REQUEST

Current Zoning: R-3 (single family residential)
Proposed Zoning: R-8MF(CD) (multi-family residential, conditional)

Approximately 38.25 acres located along the north side of Rocky River Road, west of Back Creek Road, and southeast of John Russell Road.

The petition proposes to allow up to 200 single family attached (townhome) residential units on a property containing an existing single family home that will remain and is located outside of the rezoning boundary in East Charlotte.

TYPICAL BUILDING DETAIL  
1"=40'

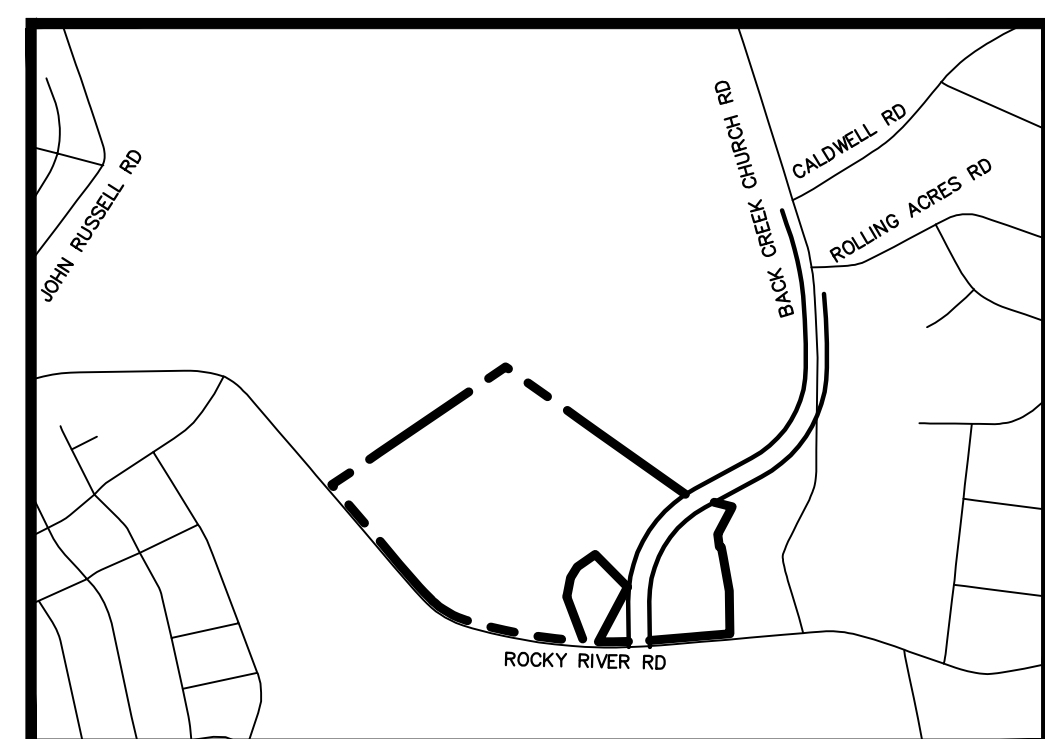
1. 4-foot Median is to be constructed on Rocky River Road. Label, dimension, and commit to proposed median.

2. The proposed berm shall be removed from the park dedication area.
3. The note needs to be revised to state that the 1.5 acres proposed park shall be dedicated and conveyed to Mecklenburg County for a future neighborhood park.
4. The site data table shows 15% tree save but there is not 15% show on the plans. Site is located in a wedge so a min of 15% of the overall site is required to be shown as tree save.

5. Specify if townhomes are to be "land for sale".
6. Add townhomes to proposed use.
7. Add to site data table: density allowed, density proposed, number of units allowed, number of units proposed.

8. Future Eastern Circumferential Road. Because of the road type setback should be discussed with staff.
9. Show and label required side and rear yards based on building orientation. This applies to the overall property boundaries not the sublots.

12. Show and label setbacks along all public streets.
13. Please clarify if this the minimum 50% open space required for R-8MF—if so remove useable common.

14. Sublots cannot be in the buffers.
15. Buffers start at the setback.
16. If any buffers are being reduced it must be noted.
17. The 20-foot garage setback is measured from the back of sidewalk or right-of-way whichever is greater is a reduced setback is used along local streets.

18. Building separation is a minimum of 16 feet.
19. The 27ft. setback can be reduced to 15ft. per section 9.303(19)(f) of the zoning ordinance if all conditions of that section are met but all garages must meet the 20ft. setback. All corner lots must also meet all requirements (including an entrance doorway on both side) if the 15ft.setback is being used. If the reduced setback is to be used this information must be noted in the site data table.
